PLANNING CONSULTATION RESPONSE

Application No	2026/0108
Proposal	Erection of 4 padel courts with a covering structure, installation of a football pitch and erection of a new associated building to include changing facilities and cafe/social areas
Address	Burntwood Sports and Leisure Centre, Common Road, Brierley, Barnsley, S72 9ET
Date of Consultation Reply	02/06/2026
Consultee	Claire Wilson, Planning Ecologist

Appendix V. ANNOTATED MAP OF THE OFF-SITE AREA PRE DEVELOPMENT.

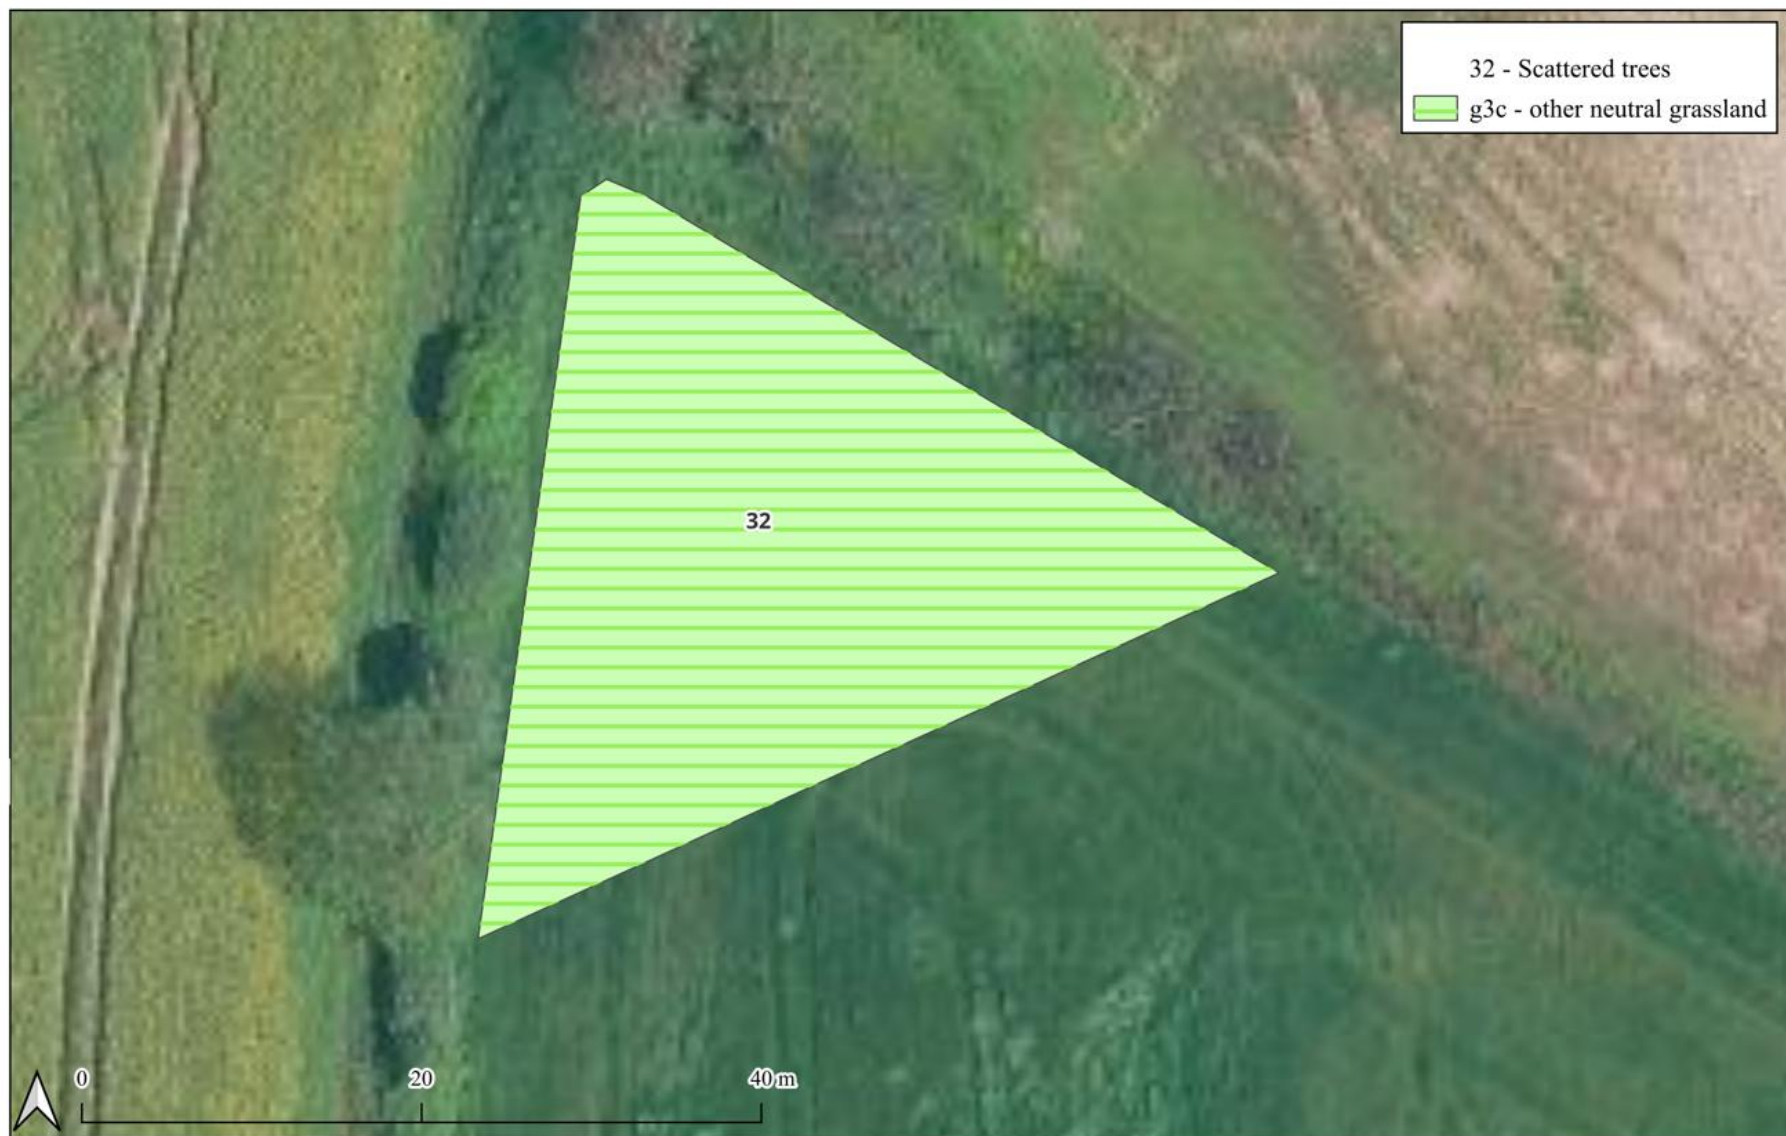
In addition, the metric indicates no improvement in condition for the off-site grassland. The baseline habitat is recorded as poor condition other neutral grassland, with the post-development habitat also remaining in poor condition. It is unclear whether this is an error, or whether the applicant does not intend to deliver moderate condition other neutral grassland at the off-site location. Clarification is required.

# Appendix IV. ANNOTATED MAP OF THE SURVEY AREA POST DEVELOPMENT.

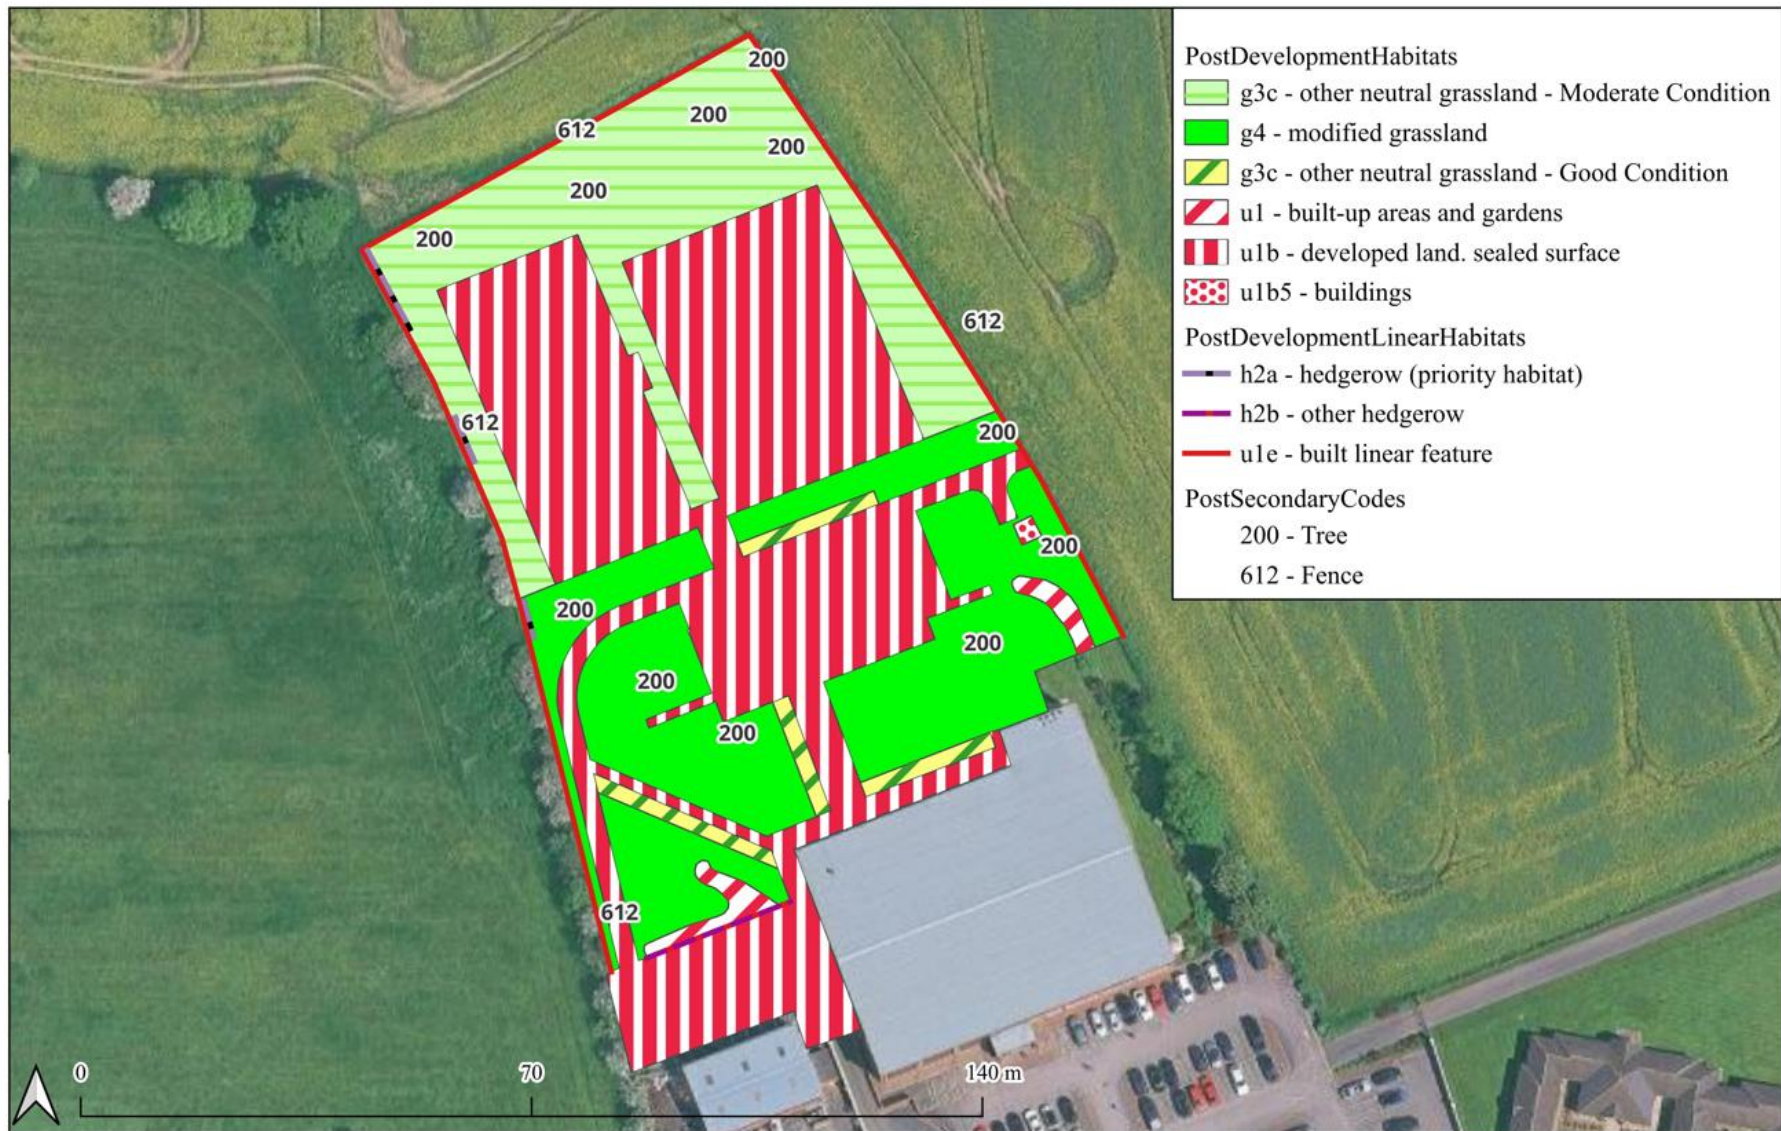
An updated EcIA and metric have been submitted. However, the report continues to propose very small areas of other neutral grassland, now in moderate condition, located directly adjacent to areas of modified grassland. As set out in my initial response, this is neither an achievable nor realistic habitat in the proposed locations, and modified grassland should instead be specified. I acknowledge that revising the habitat in this way will result in the scheme failing to achieve the required 10% biodiversity net gain. Accordingly, it is recommended that the applicant increases the extent of off-site provision to secure the necessary uplift.
